WEST SUSSEX COUNTY COUNCIL CONSULTATION

TO:	Arun District Council FAO: Simon Davis
FROM:	WSCC - Highways Authority
DATE:	21 February 2020
LOCATION:	Land north of Yapton C of E Primary North End Road Yapton BN8 0DU
SUBJECT:	Y/17/20/PL Construction of a new access to serve residential development This application may affect a Public Right of Way.
DATE OF SITE VISIT:	n/a
RECOMMENDATION:	More Information
S106 CONTRIBUTION TOTAL:	n/a

Client		
DANDARA LIMITED (SOUTHERN)		
Scale	Date	Designed
1:250 @A1	OCT 19	CJL
Drawn	Checked	Approved
CJL	SW	JHM
Job No	Drawing No	Rev
19-156	YAP-S278-01	D

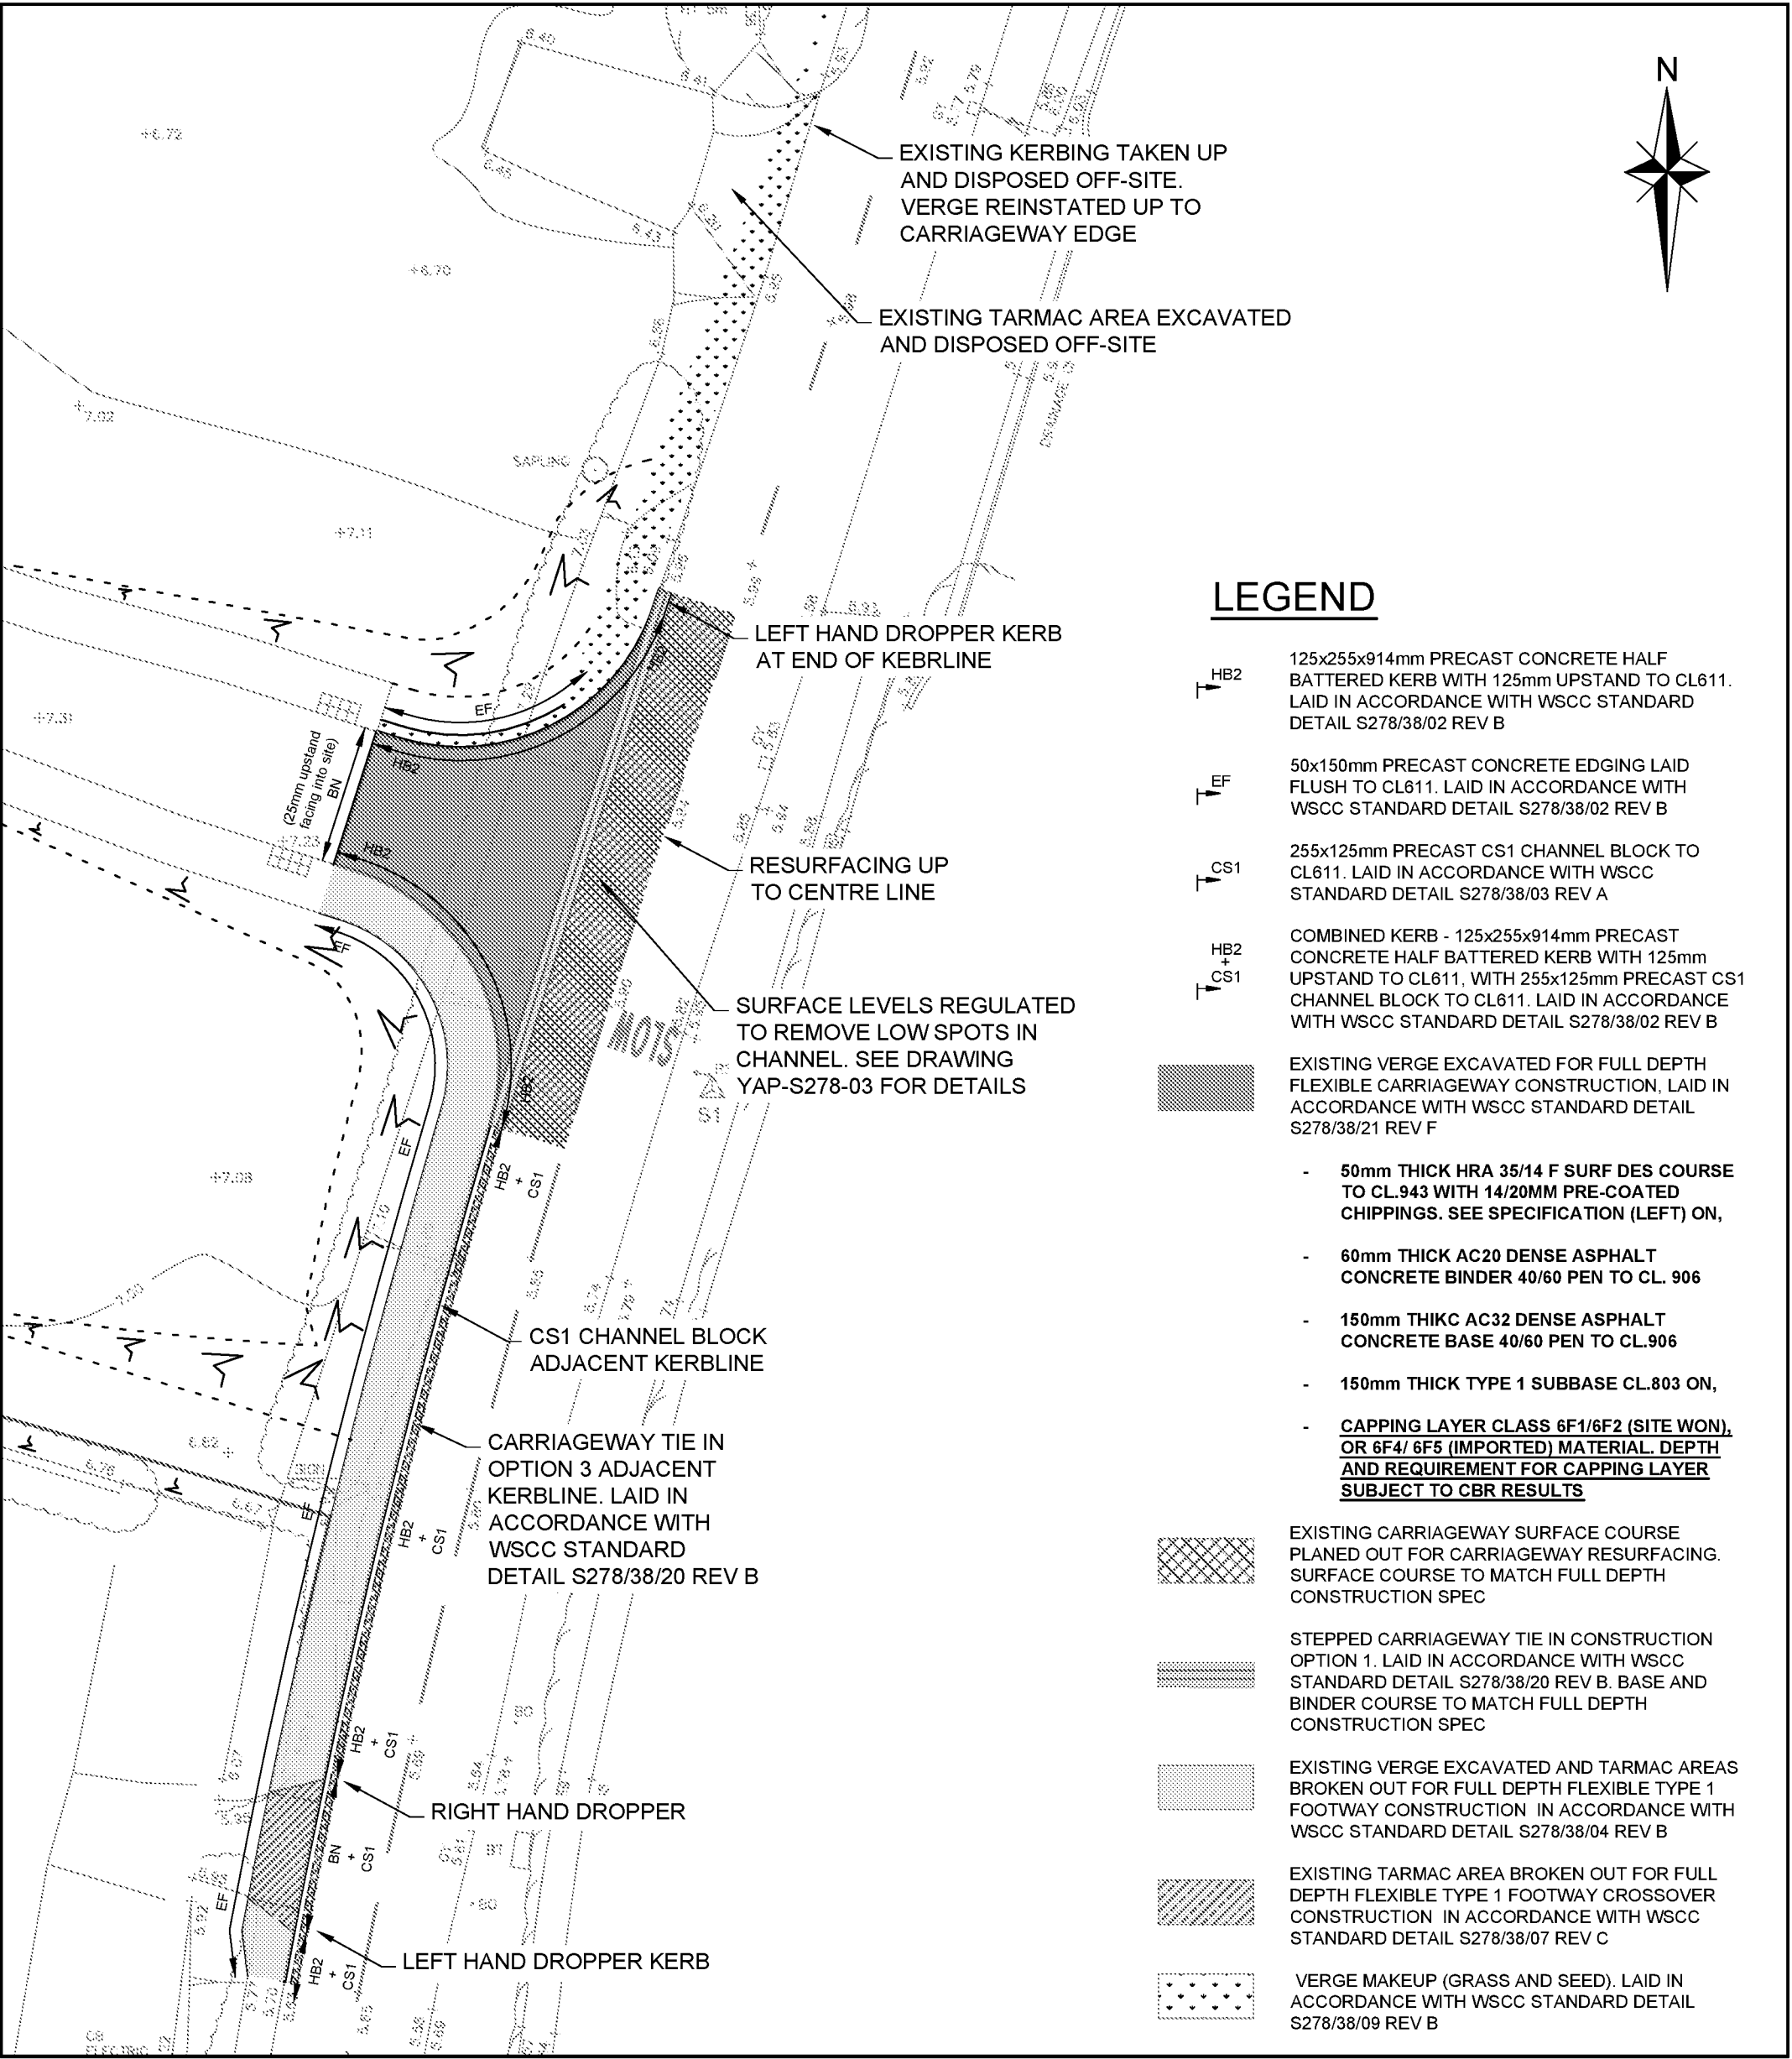
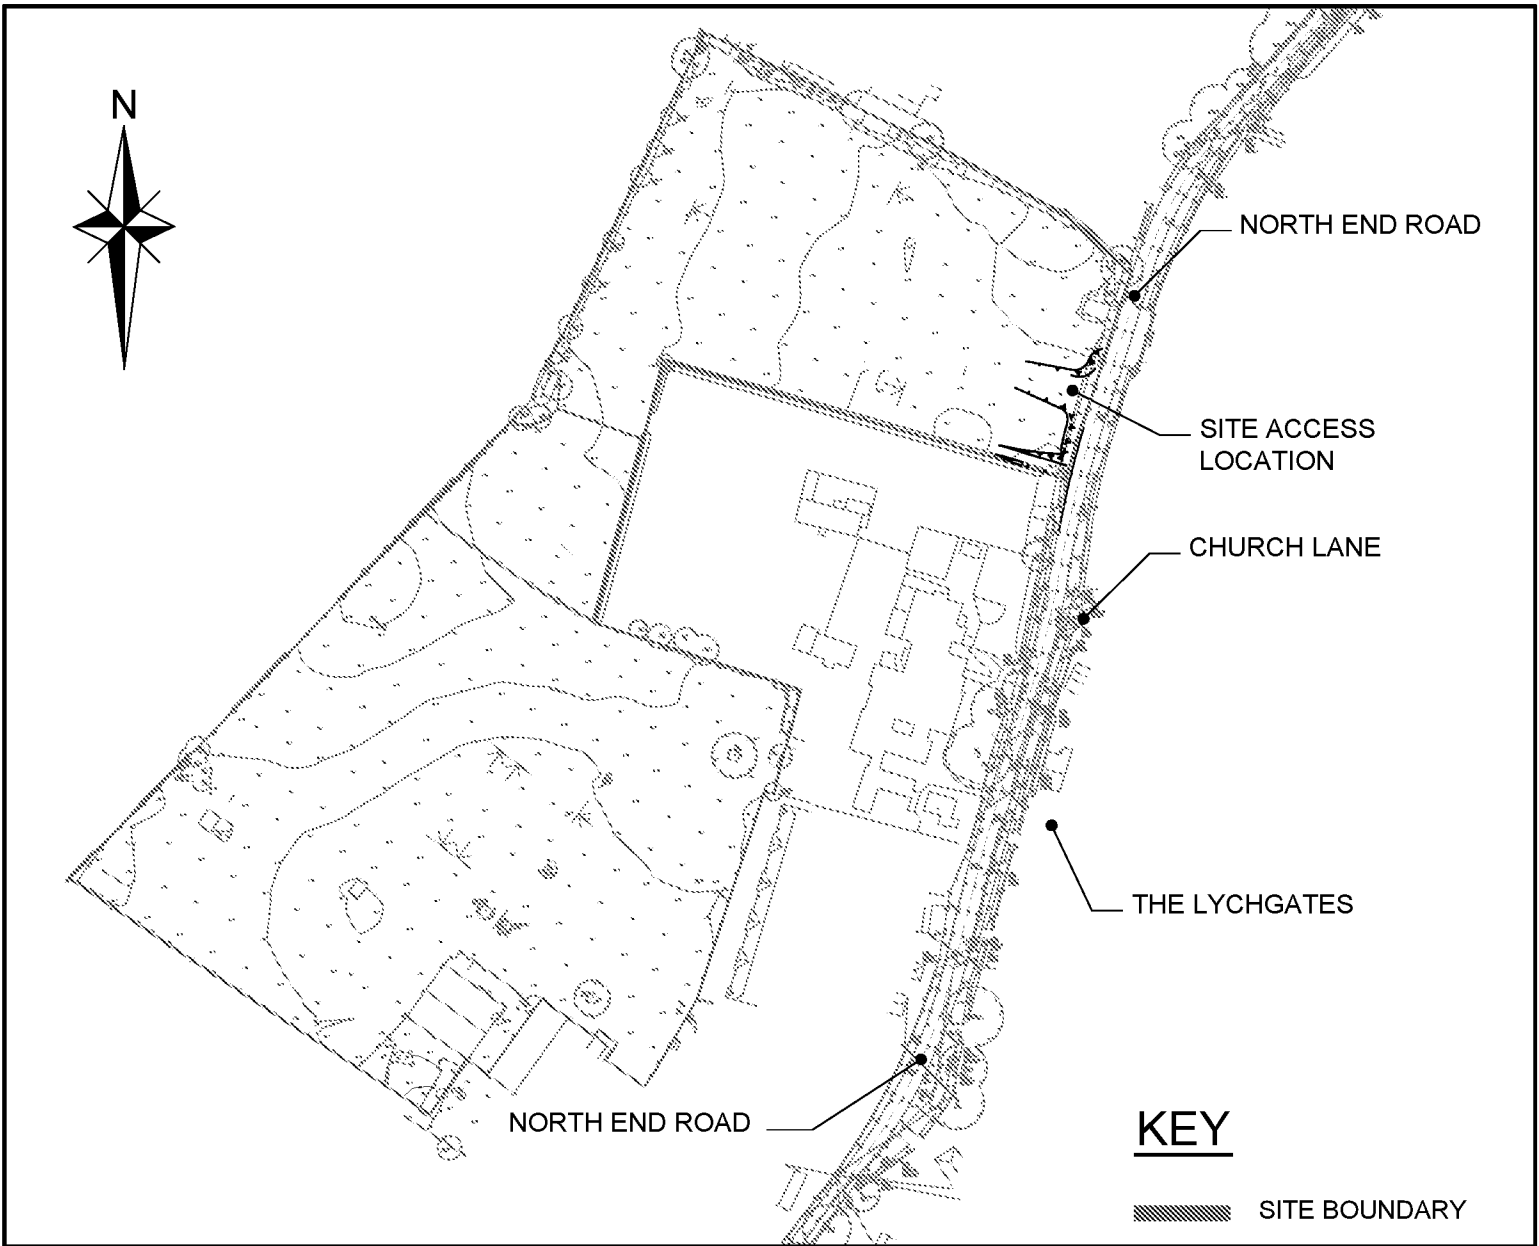
The LHA advise the Local Planning Authority (LPA) that there is currently an ongoing live section 278 agreement without technical approval for this access. As a result, the submitted S278 General Arrangement drawing is potentially subject to change.

With the approval of the Clays Farm Development to the north of the site, the LHA request the applicant provides a footway/pavement along the site frontage to link with the existing footway to the south and the Clays Farm Development site. This should be supported with a Stage 1 Road Safety Audit.

Construction Access Map

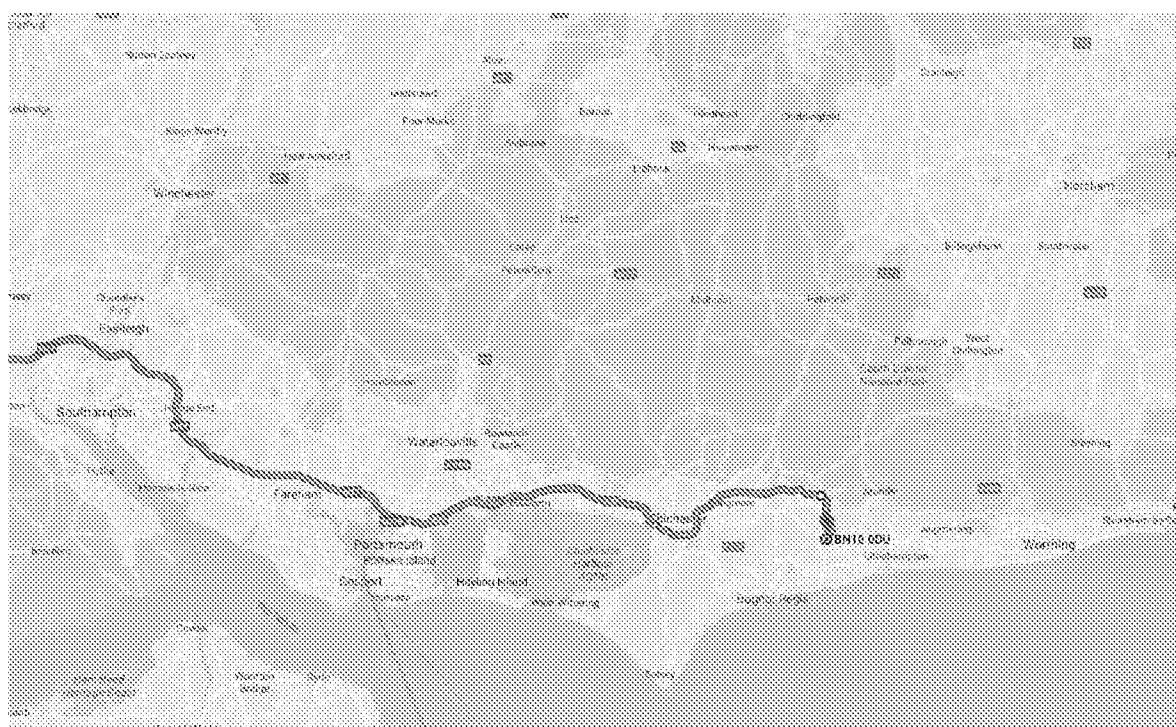
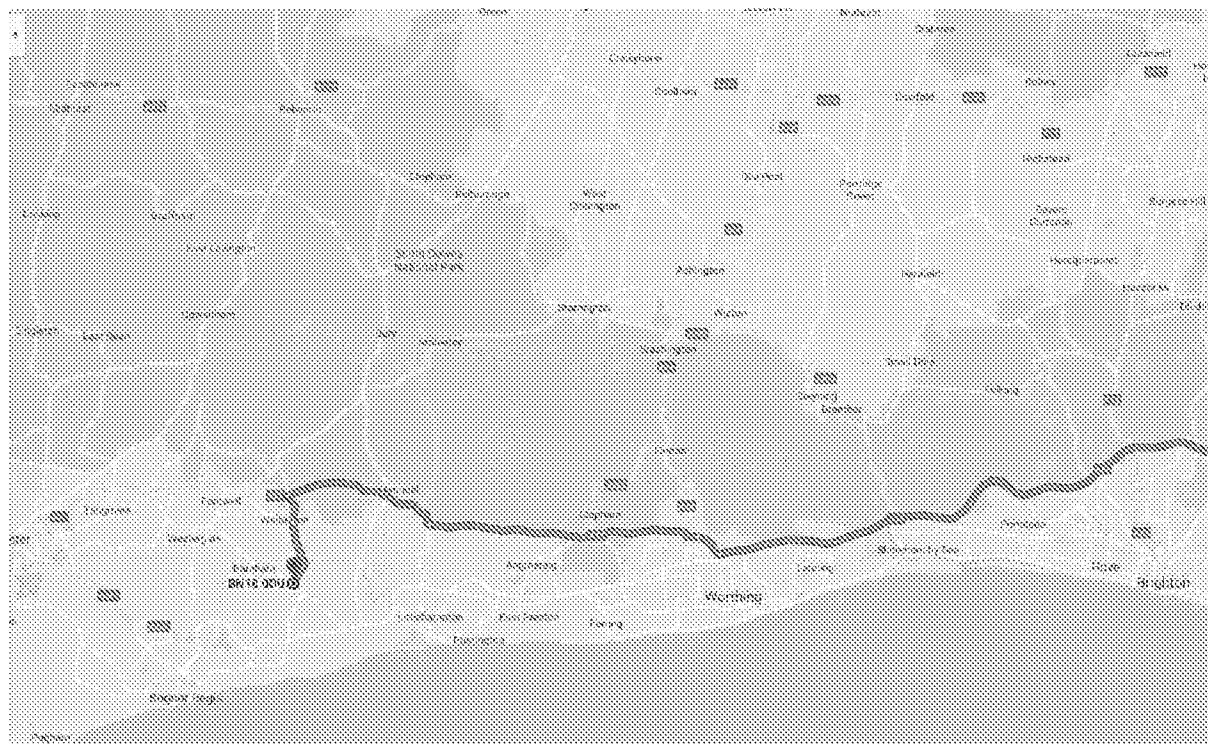
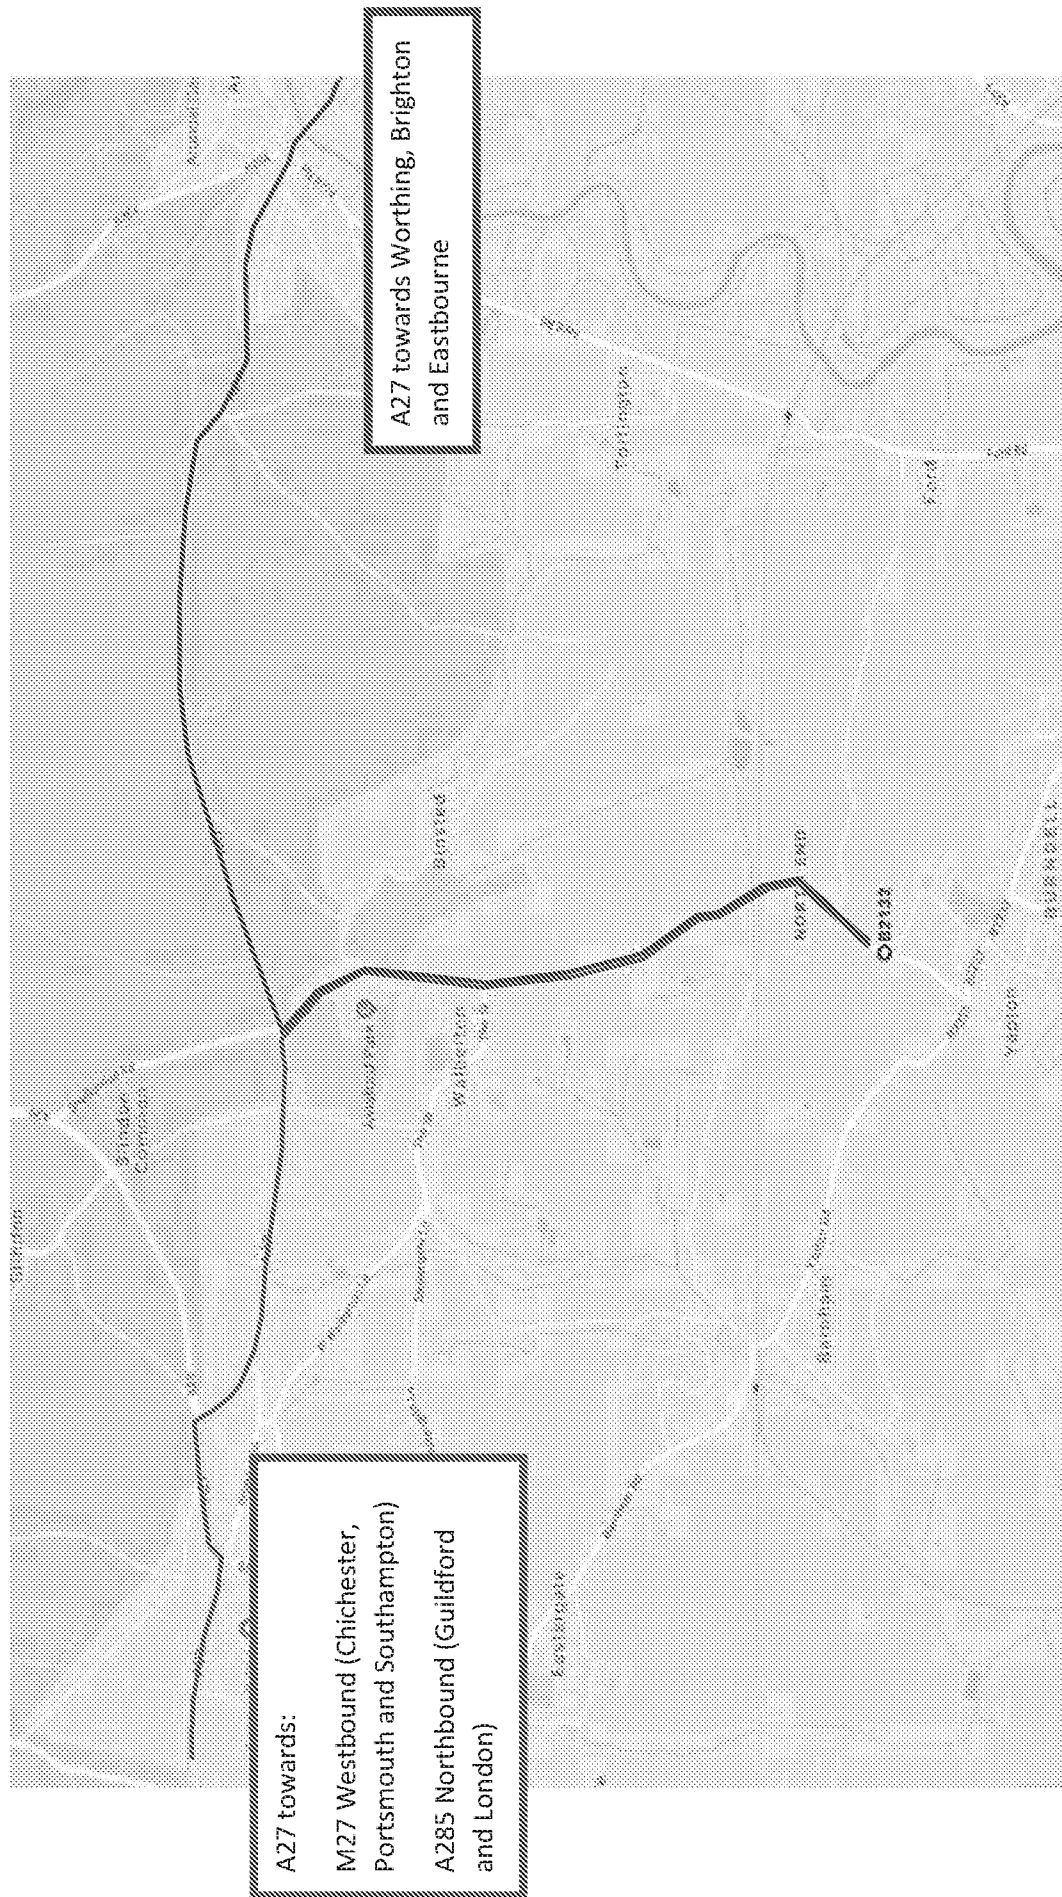
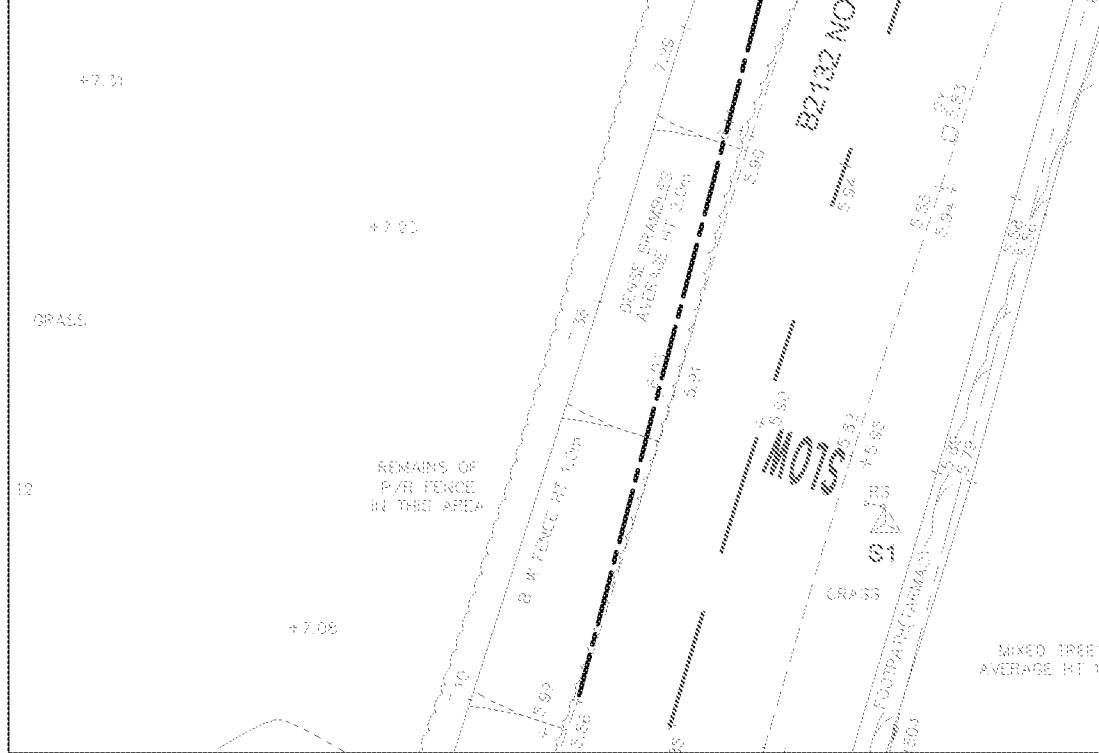
The plans attached to the CMP are 'cut up' please provide full plans within the CMP so that the LHA can provide substantive comments on this matter. This matter could be secured via a suitably worded condition.
